From: Chris Flint [REDACTED]
Sent: 13 March 2018 11:30
To: Juan Baeza
Cc: Kelly Lewis
Subject: Re: LU/280/17/PL

Drawing Title :
Proposed Conversion Floor Plans

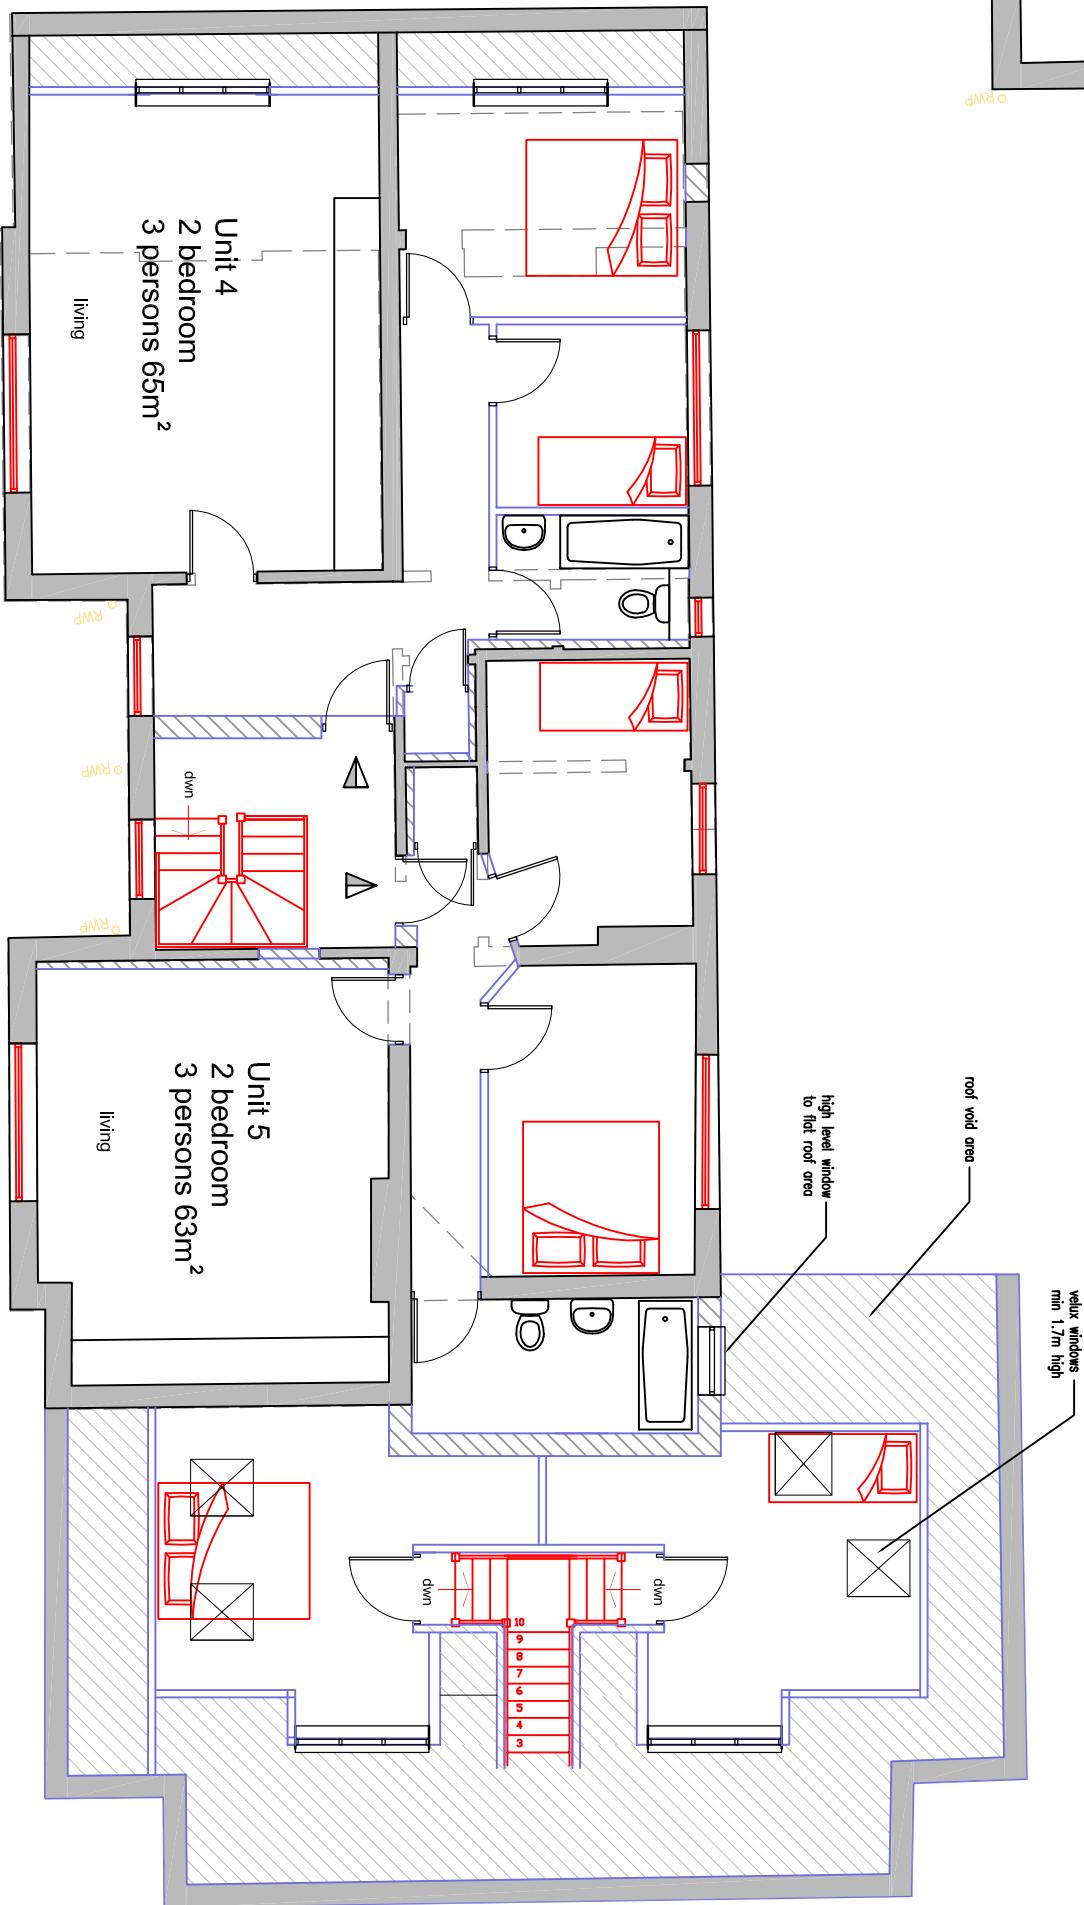
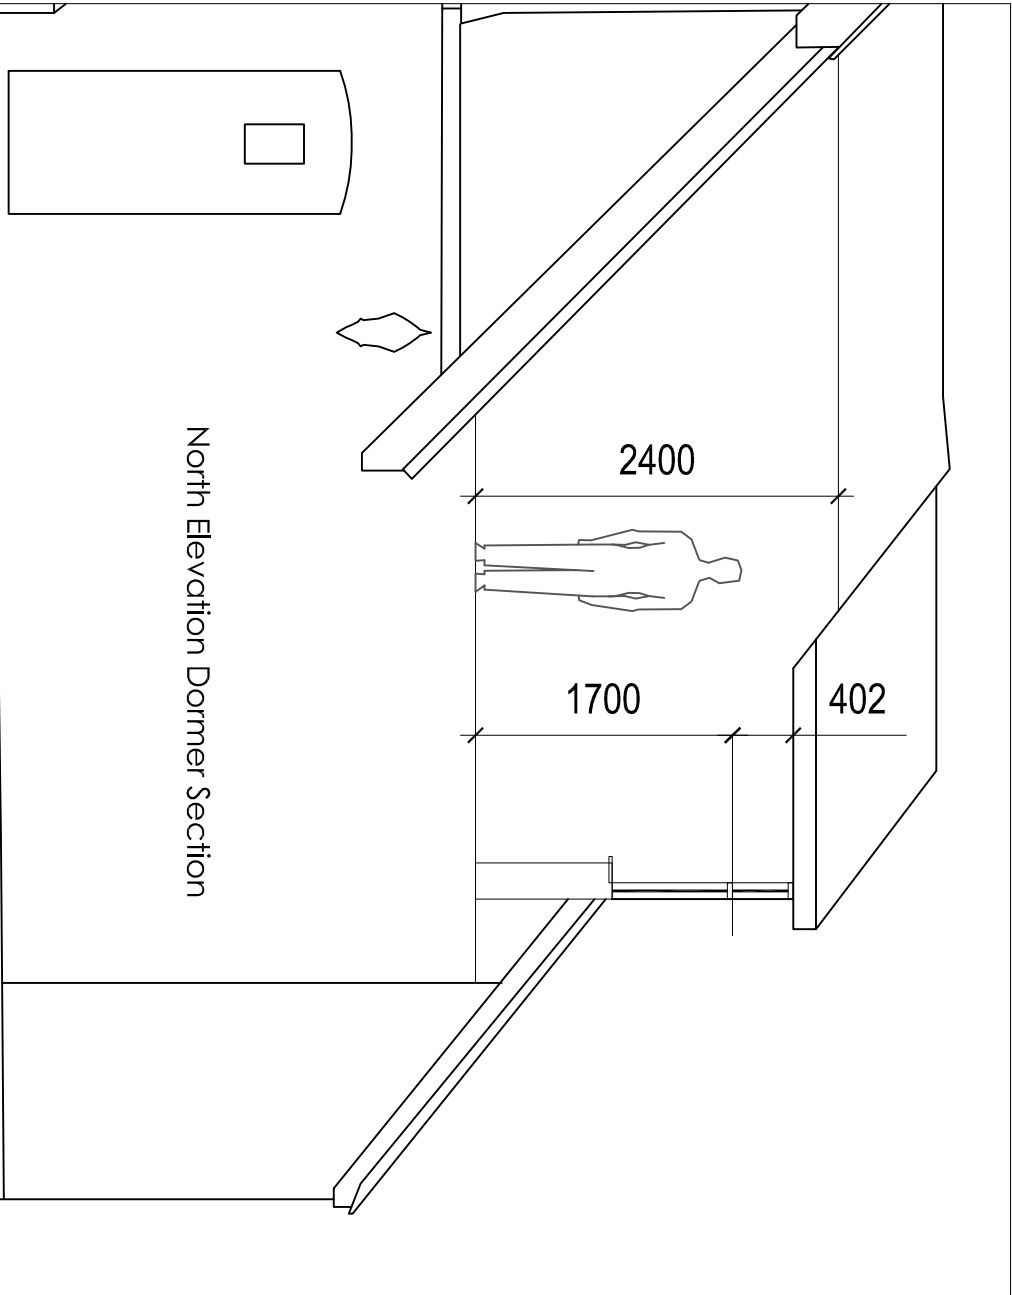
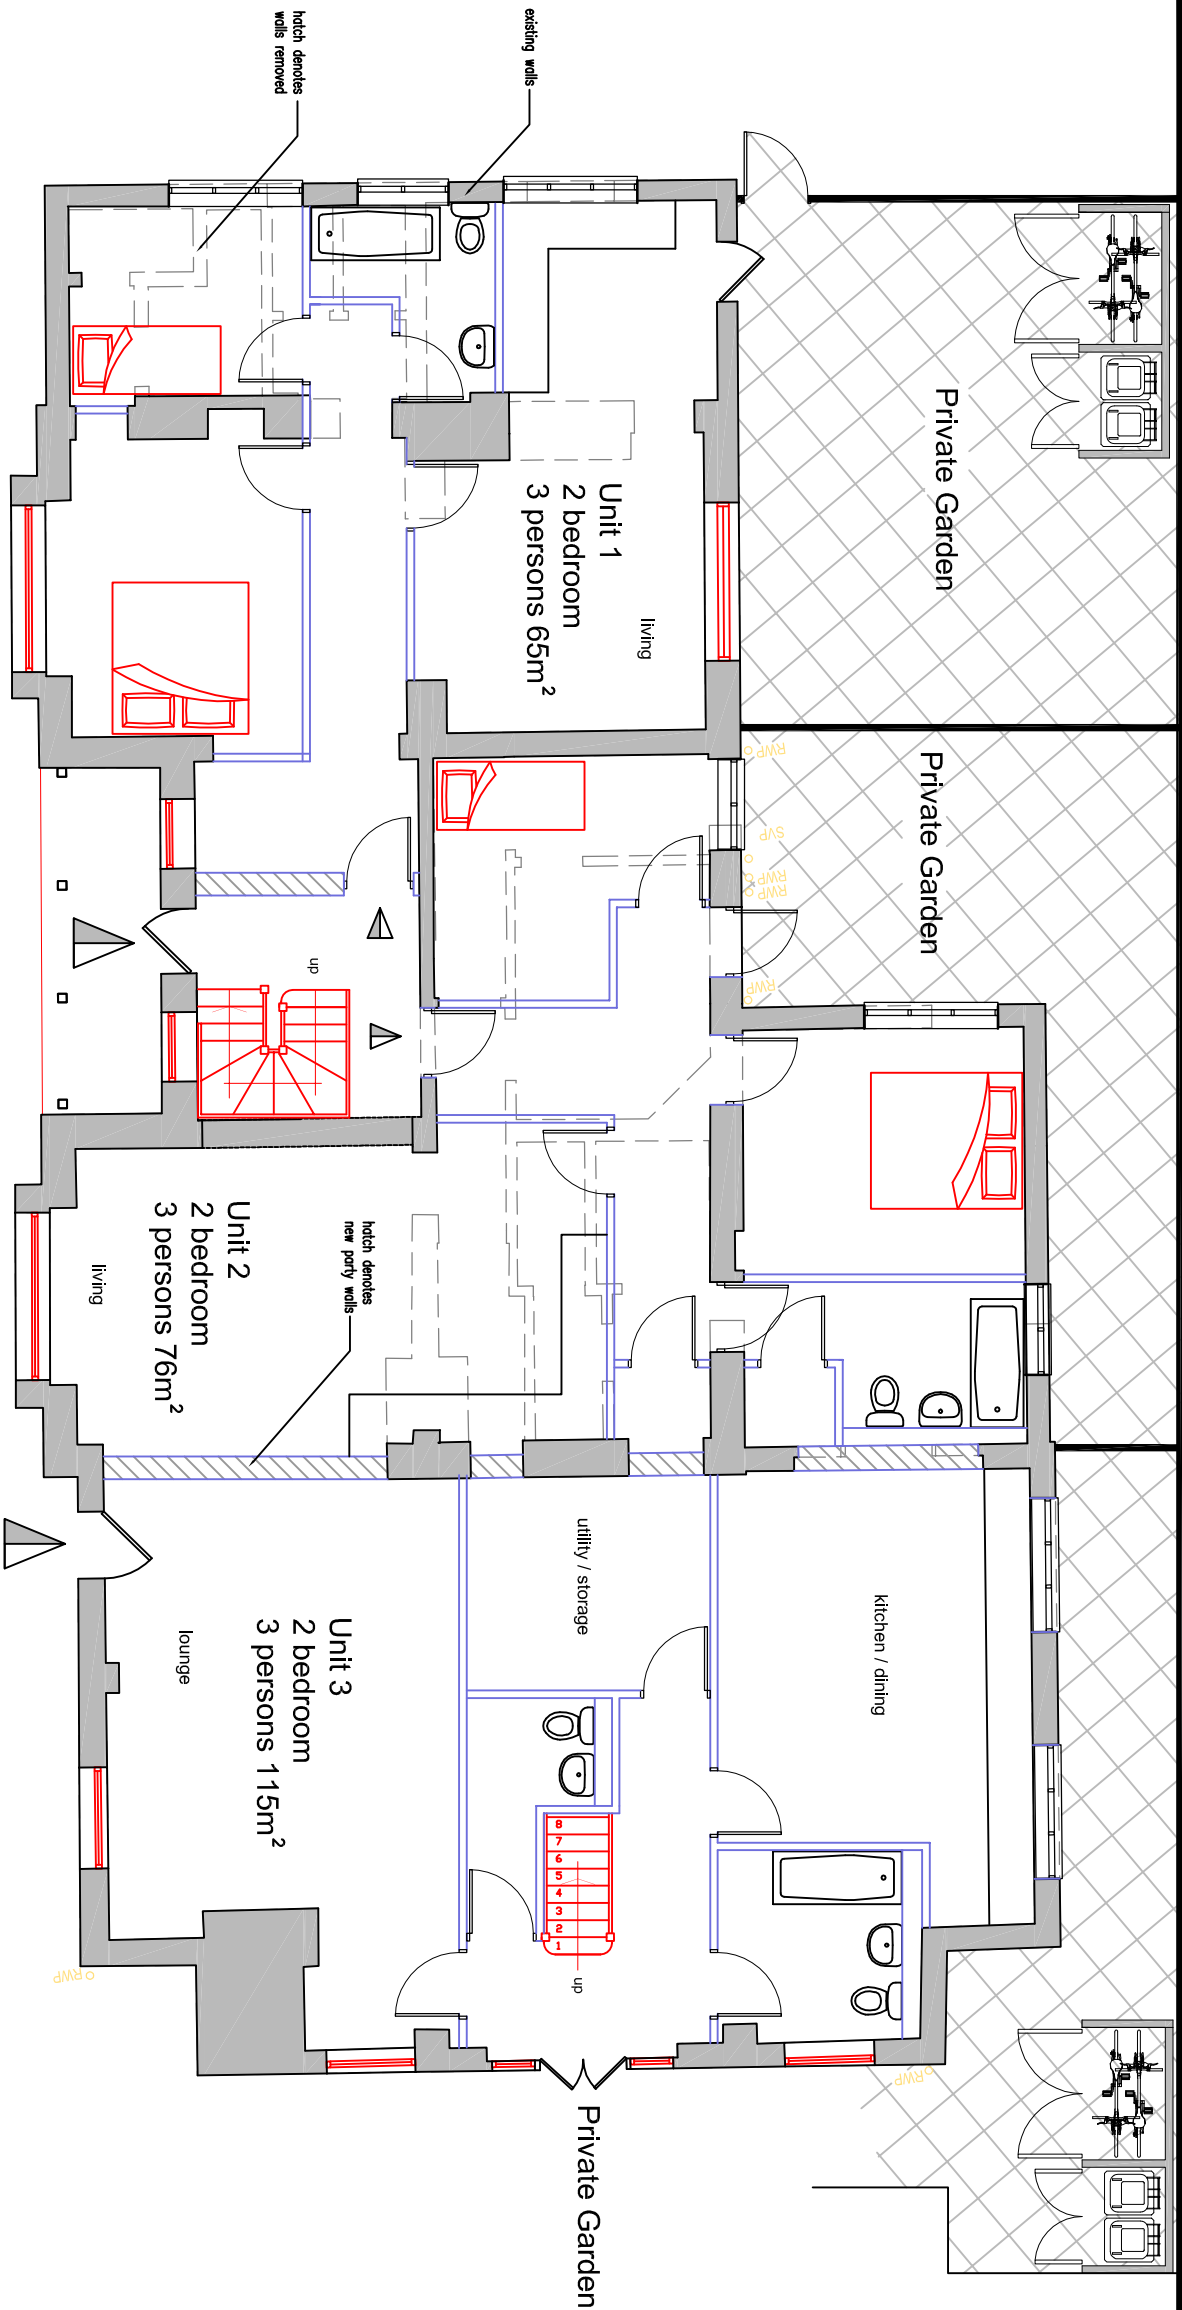
This application is down for tomorrows Development Control Committee. As a matter of urgency I would like confirmation, preferably by way of a cross section drawing, that the two proposed dormers on the northern roof slope will be able to be provided with a section of glass that is non obscure and able to open notwithstanding condition number 3 which states :

Further to our conversation please find attached amended drawings to show fixed windows to a height of 1.7m on the north elevation dormer we also show a section with a opening fan light above 1.7m we have also added a number of velux windows again non-openable at 1.7m but providing additional light and ventilation.
